KITTITAS COUNTY DEPARTMENT OF PUBLIC WORKS

MEMORANDUM

TO: Jeff Watson
FROM: Christina Wollman, Planner II *sw*
DATE: March 12, 2010
SUBJECT: Bronkema Accessory Dwelling Unit AU-10-00001

BRONKEMA SITEMAP
w/ ADU

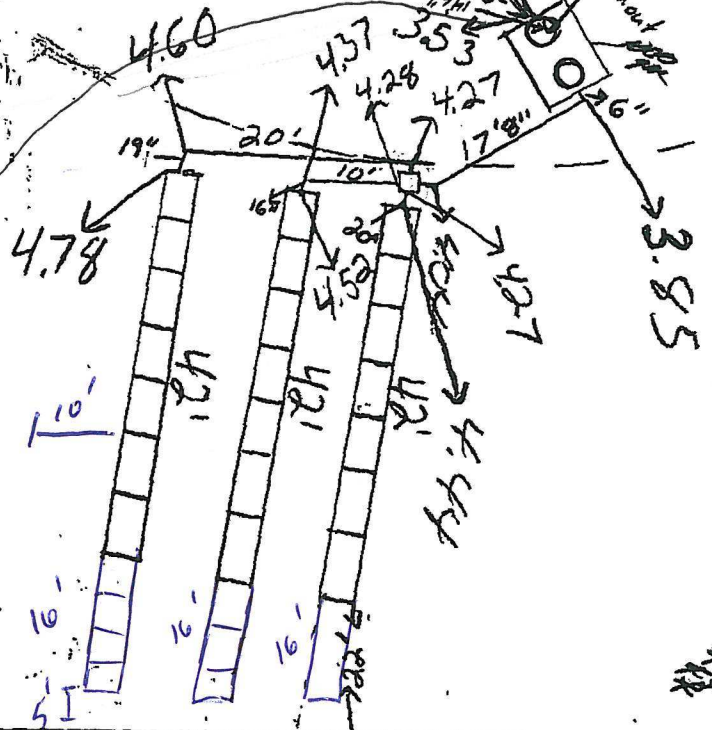
- A. Access: Access to the proposed new residence shall be from the existing driveway leading to the primary residence, as noted by the applicant. The applicant must adhere to all regulations set forth in the Kittitas County Road Standards.
- B. Access Permit: An approved access permit will be required from the Department of Public Works prior to creating any new driveway access or performing work within the county road right of way.
- C. Addressing: Contact the Kittitas County Rural Addressing Coordinator at (509) 962-7523 to obtain addresses prior to obtaining a building permit. A parcel cannot receive a building permit or utilities until such parcel is identified with a 911 address.
